Rezoning Transportation Analysis

Petition Number: Insert Zoning Petition #2021-258

Revision Log:

Date	Description
04-28-22	First Review (PDM)
05-25-2022	Second Review (KP)
06-29-2022	Third Review (PDM)

REZONING SITE PLAN

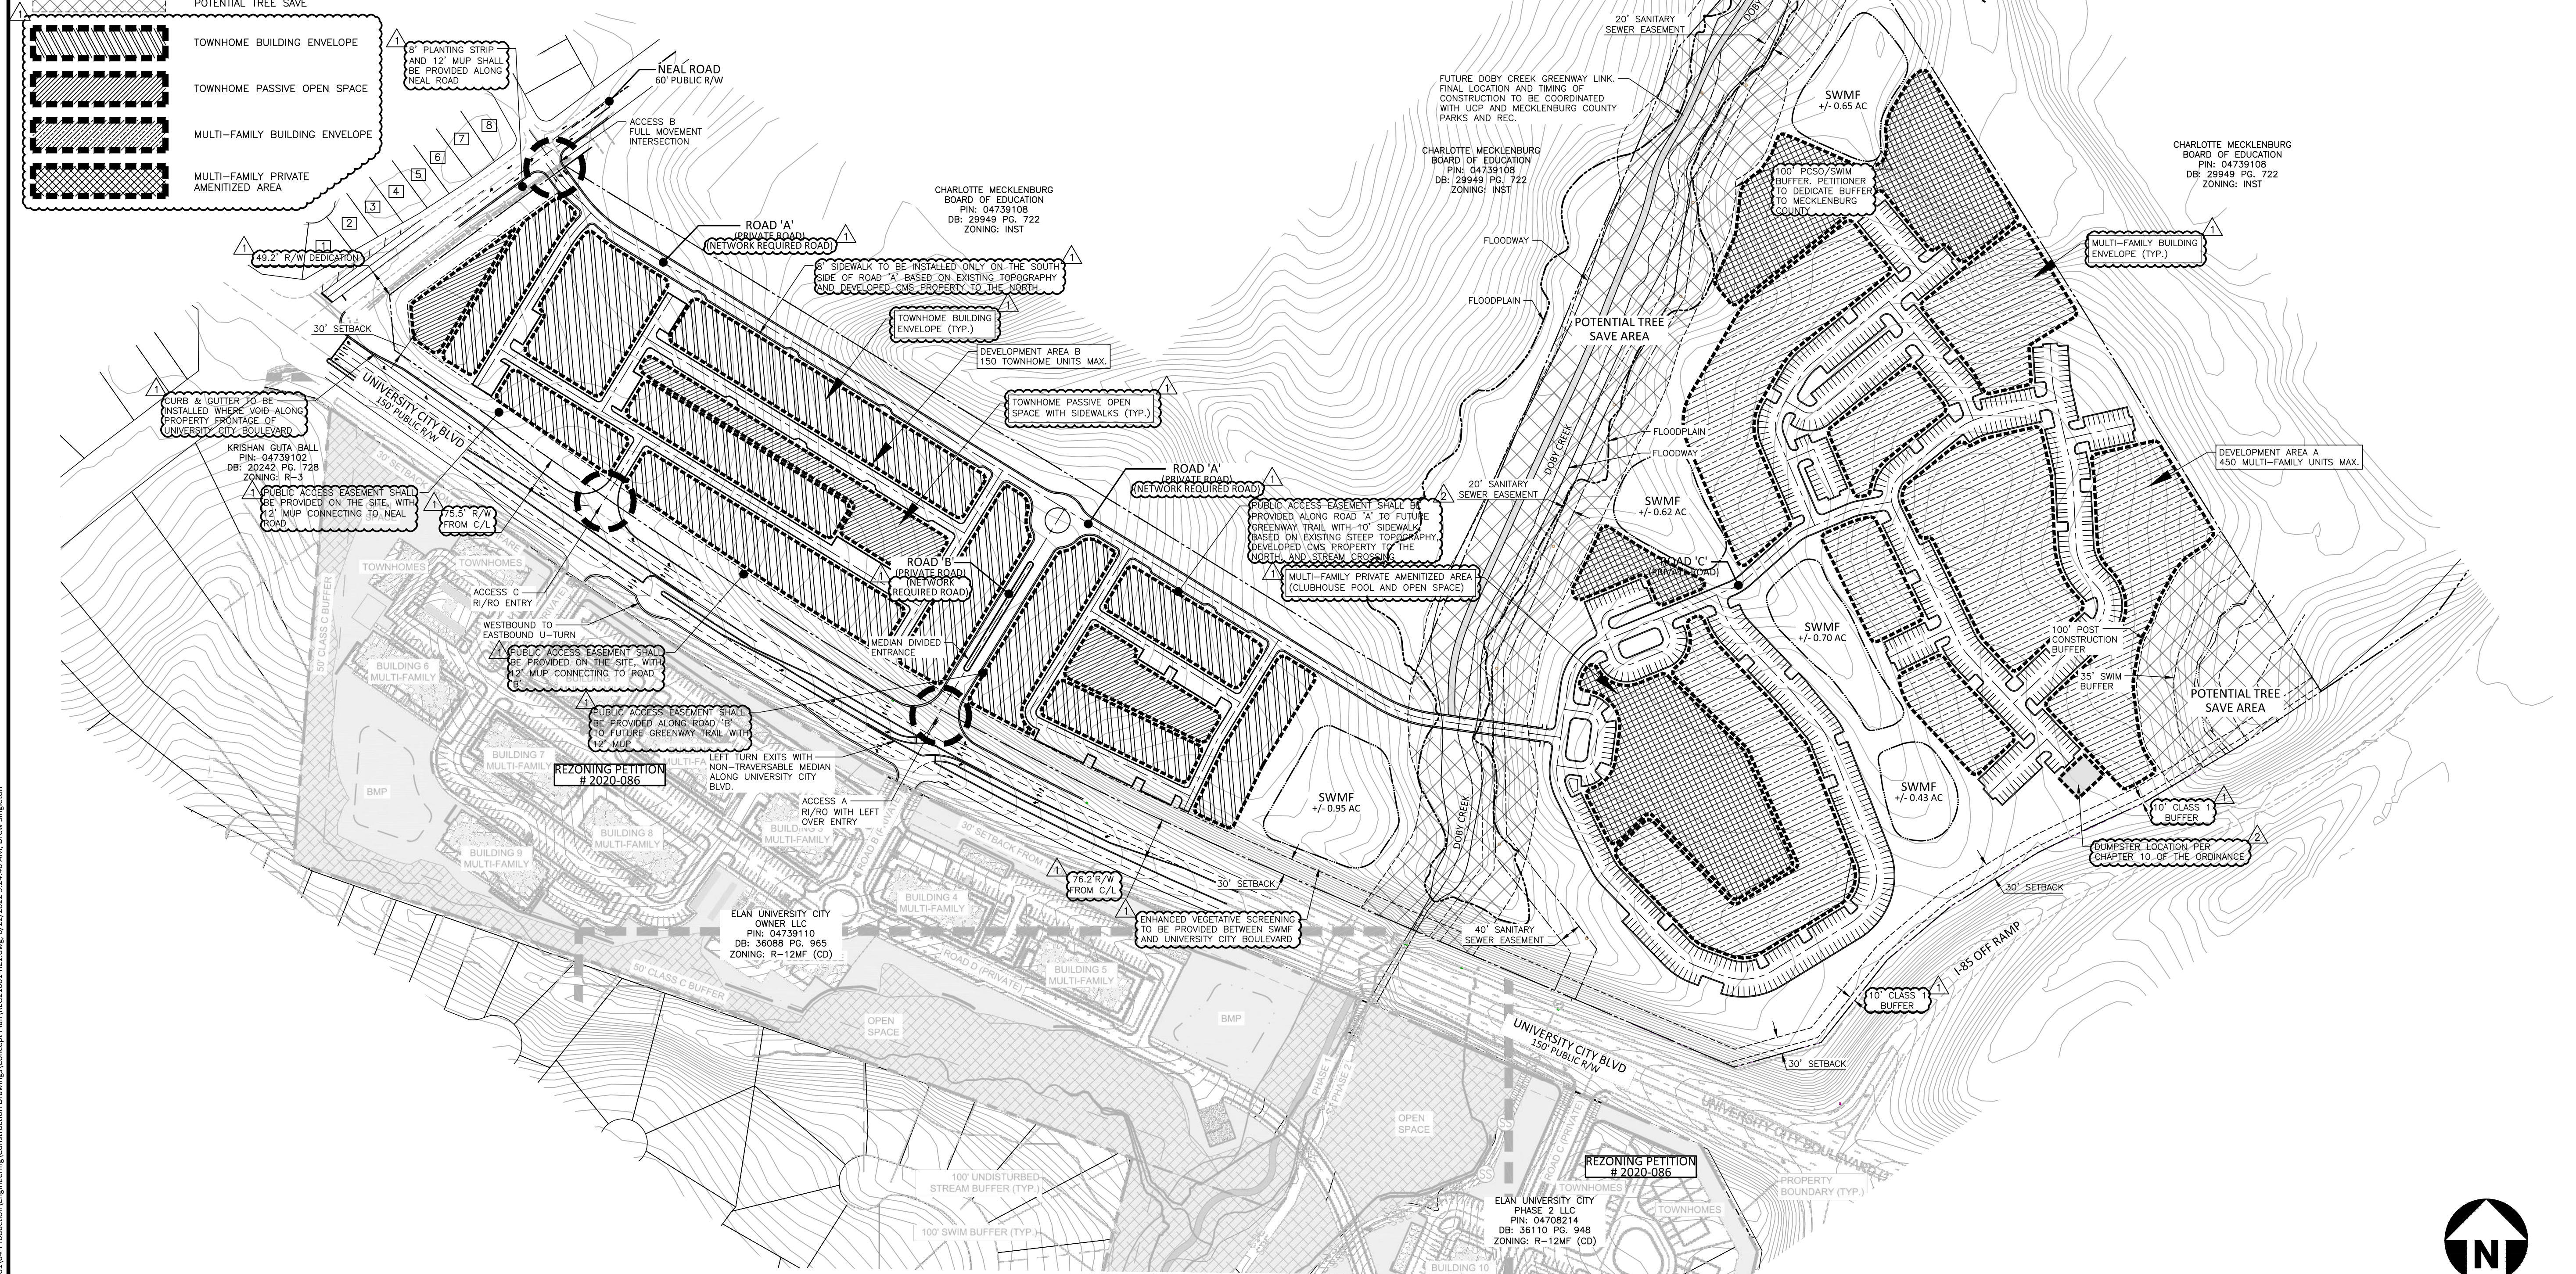
10. **Outstanding comment from 04.28.22:** ~~Revise site plan and conditional note(s) to provide the typical sections for all internal private roads. CDOT recommends using the location residential median street~~

typical section with 8-foot sidewalks per CDLSM U-02. Sidewalks will be required along all private streets. If roads will be built to private street standards specify the appropriate CLDSM typical section.
